POST RESPONSE TO SUBMISSIONS REPORT

ALEX AVENUE PUBLIC SCHOOL_SSD_9368

This supplementary Response to Submissions (RtS) Report has been prepared to respond to further submissions received in relation to SSD 19_9368 for 'Alex Avenue Public School'.

1 Roof Top Barge Detail - Dependent 1
SCALE 1:5

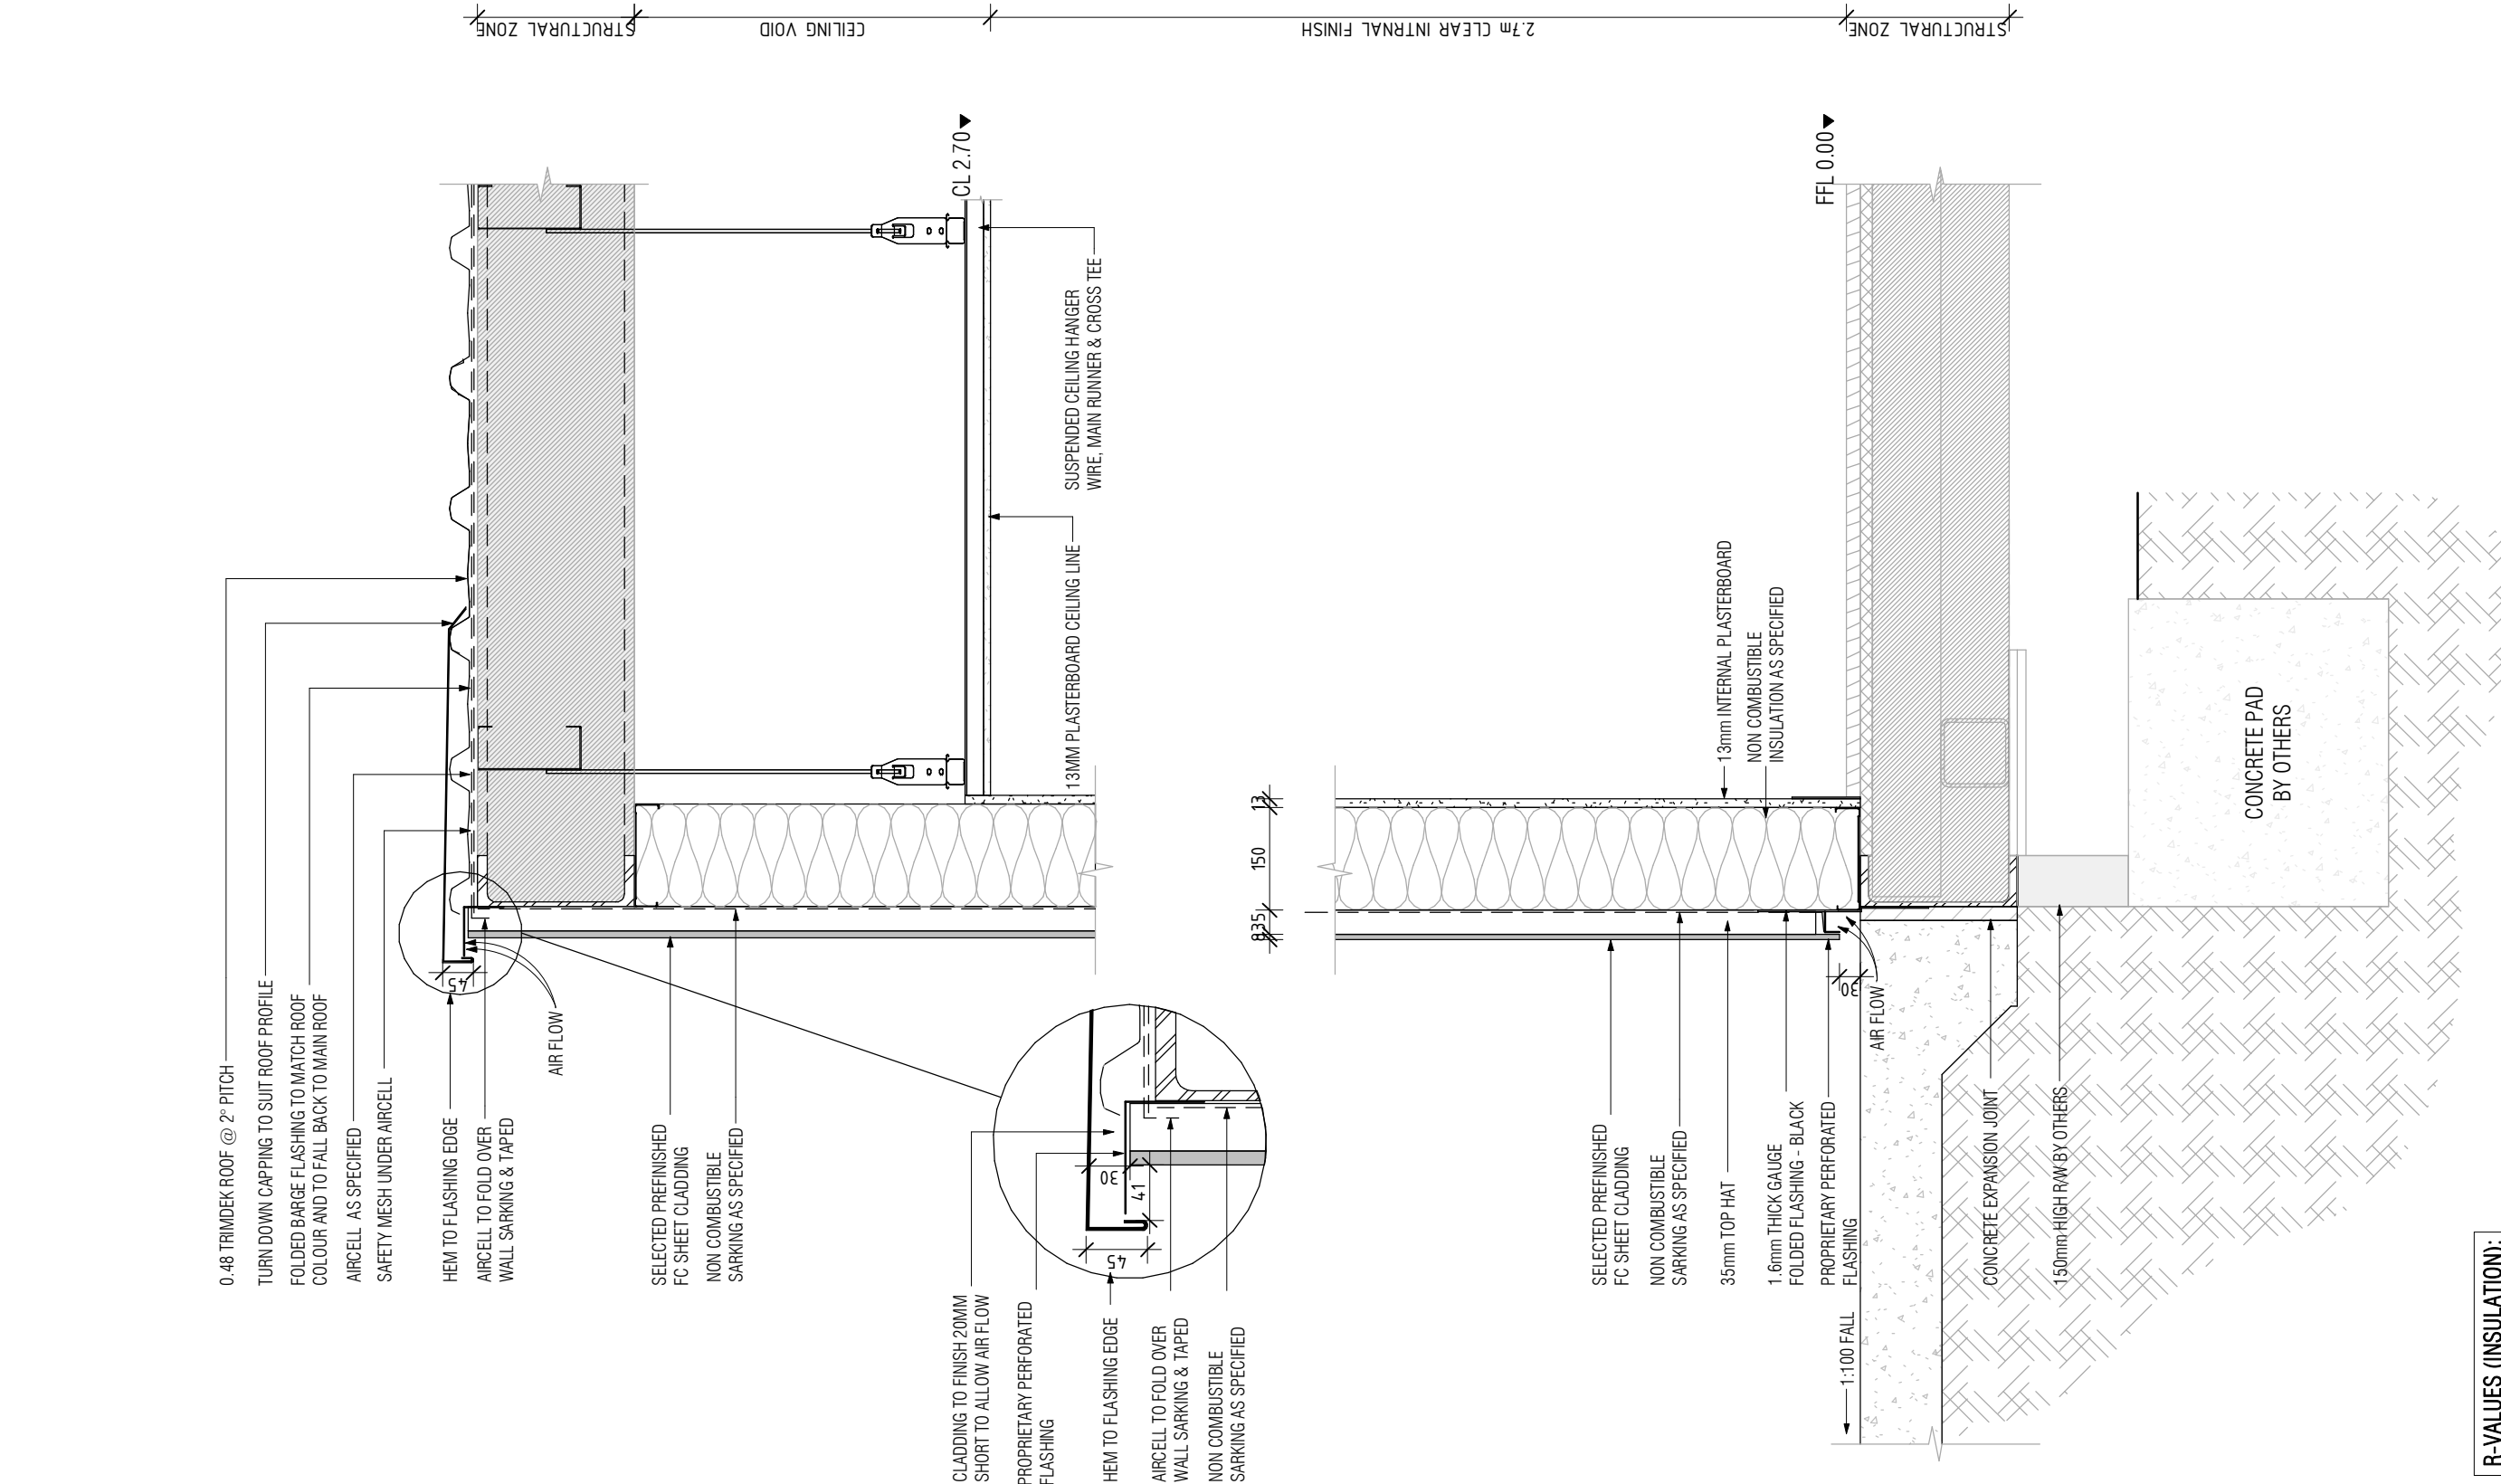
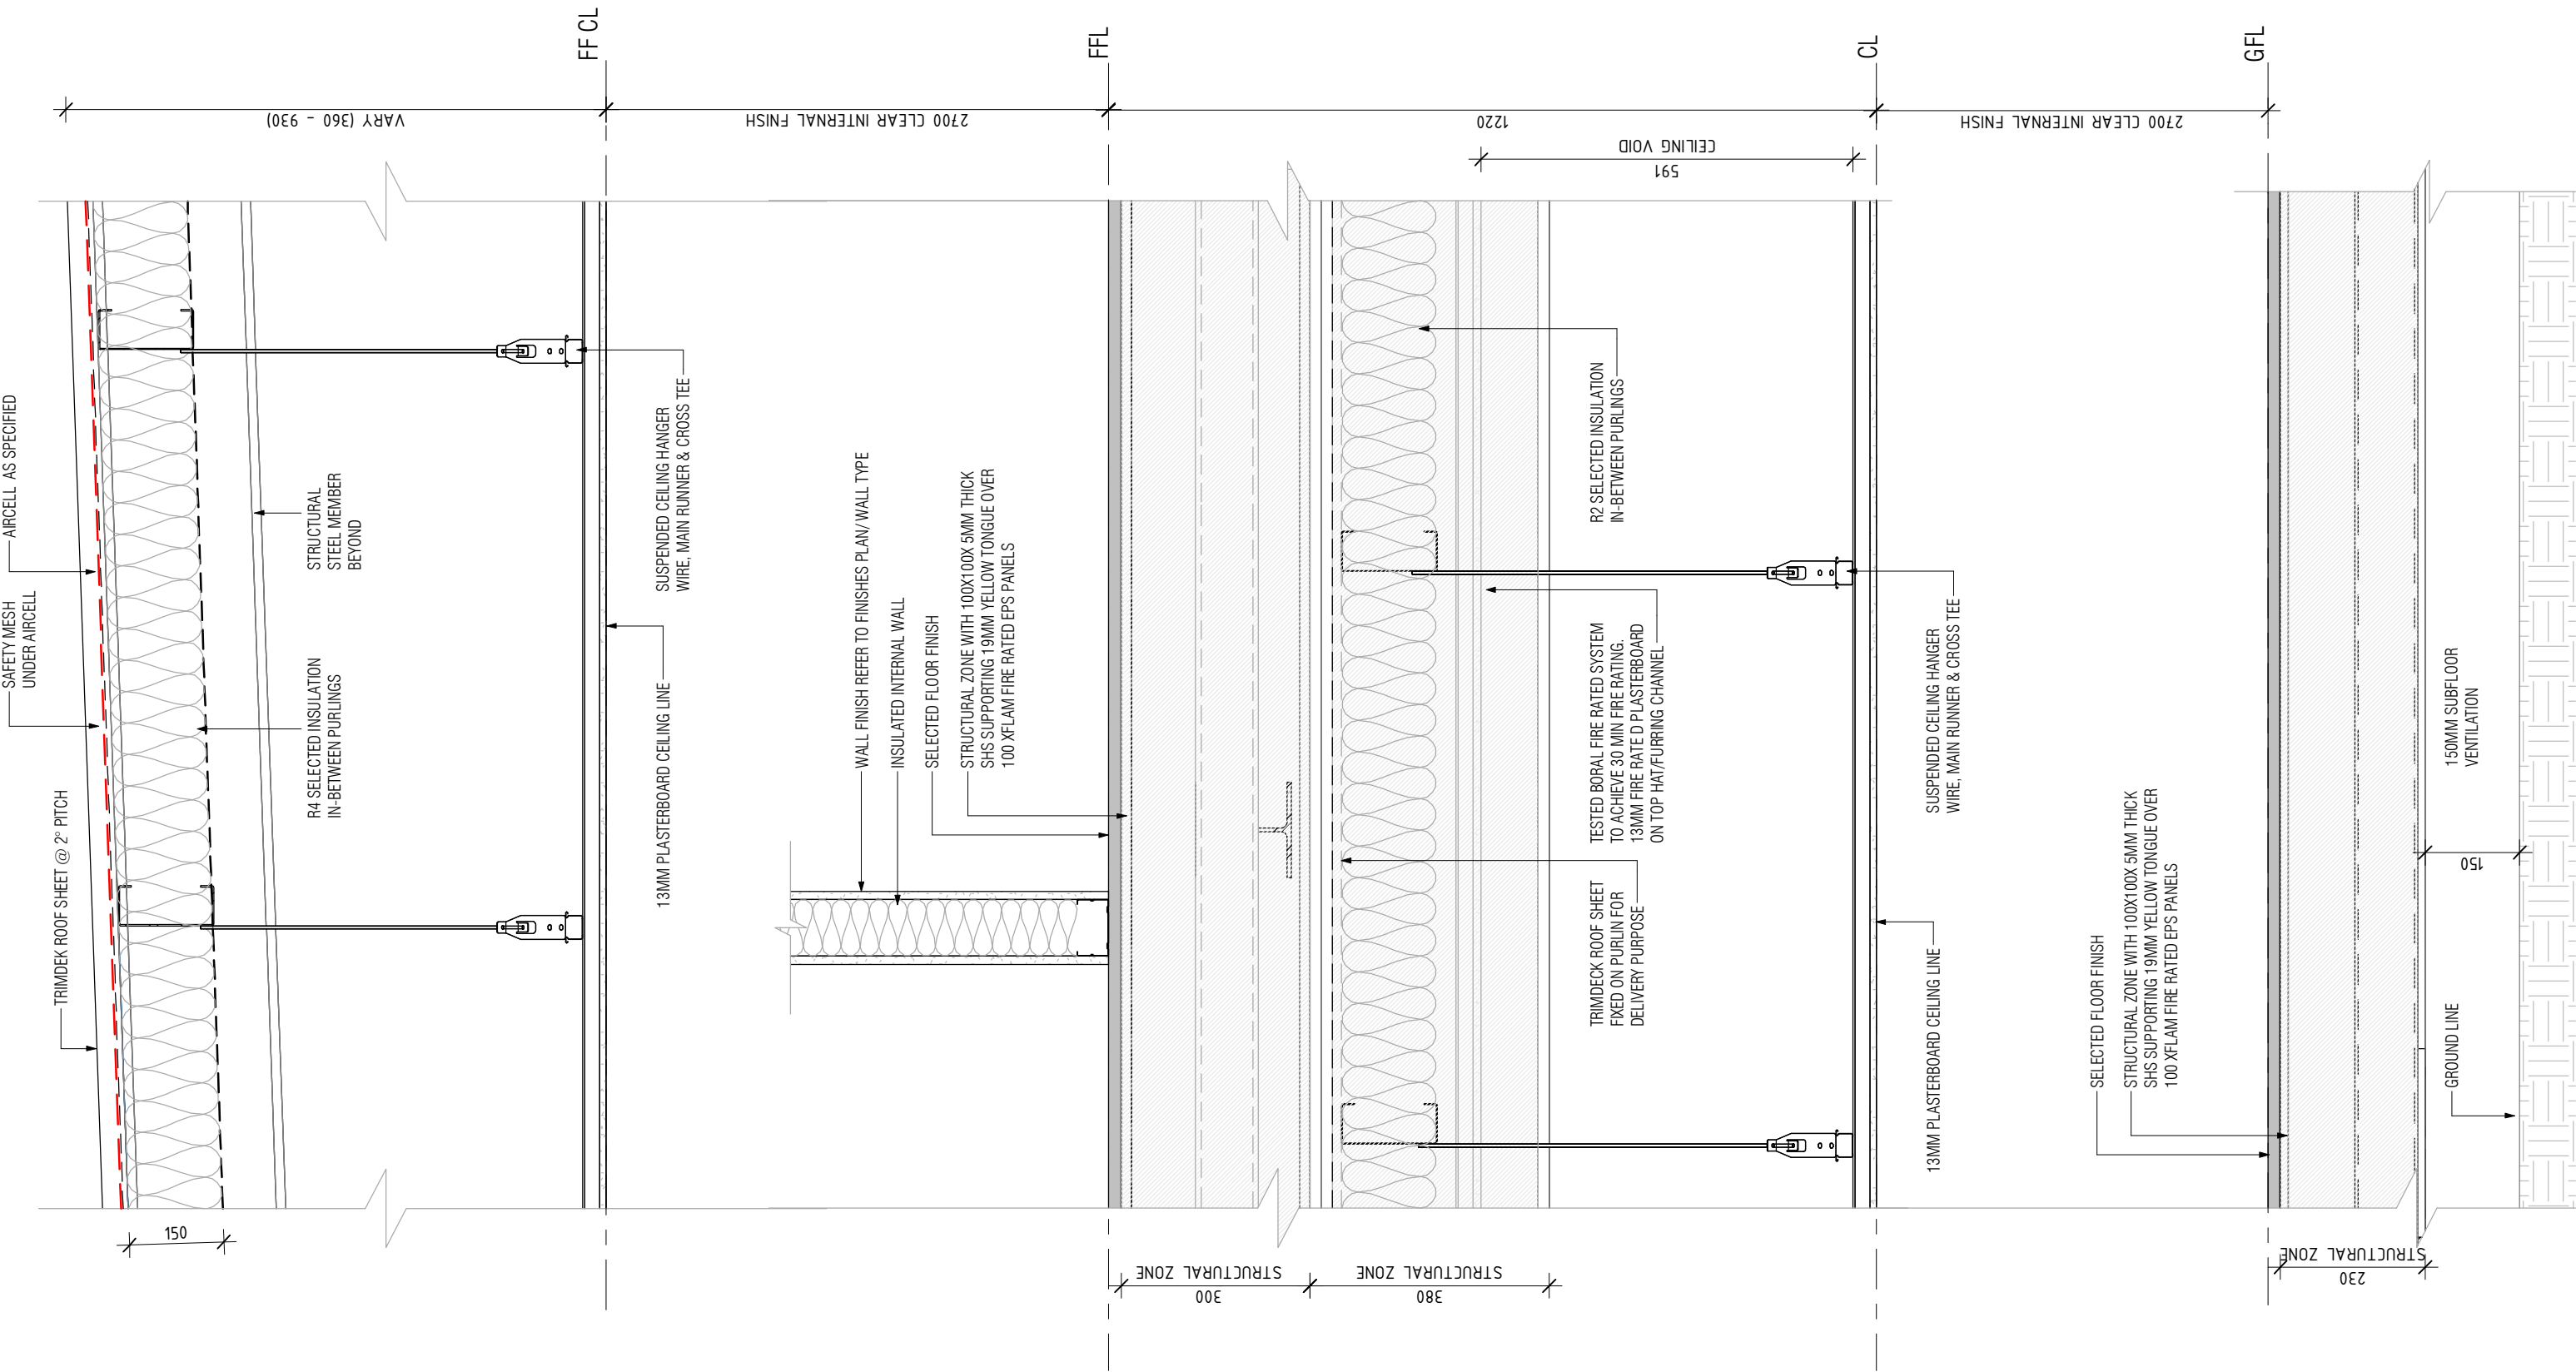
7.	The COLA structures and walkway eaves as illustrated lack construction credibility. Construction details, particularly through the edge condition should be provided.	As outlined further in Appendix A , the COLA structures are reinforced concrete frames, consisting of steel screw piles founded in siltstone with reinforced concrete pile caps, reinforced concrete columns and beams with reinforced concrete first floor slabs. Lateral stability of the COLA concrete frame structure is provided by frame action. The COLA roofs are steel framed structures, consisting of steel rafters, steel purlins and steel columns. All steel sections are 'open' sections except	Appendix A

Issue	Comment	DoE Response	Reference
		for the steel columns, which are “closed” SHS members. Lateral stability of the COLA steel framed roof structures is provided by steel portal frame action. The edge condition of the COLA roofs are made up of fully welded angles at required centres, fixed back to the structural steel. The cladding and soffit lining are supported via a top hat subframe and plywood substrate. Detailed plans of the COLA structures are provided in page 11 of Group GSA’s letter.
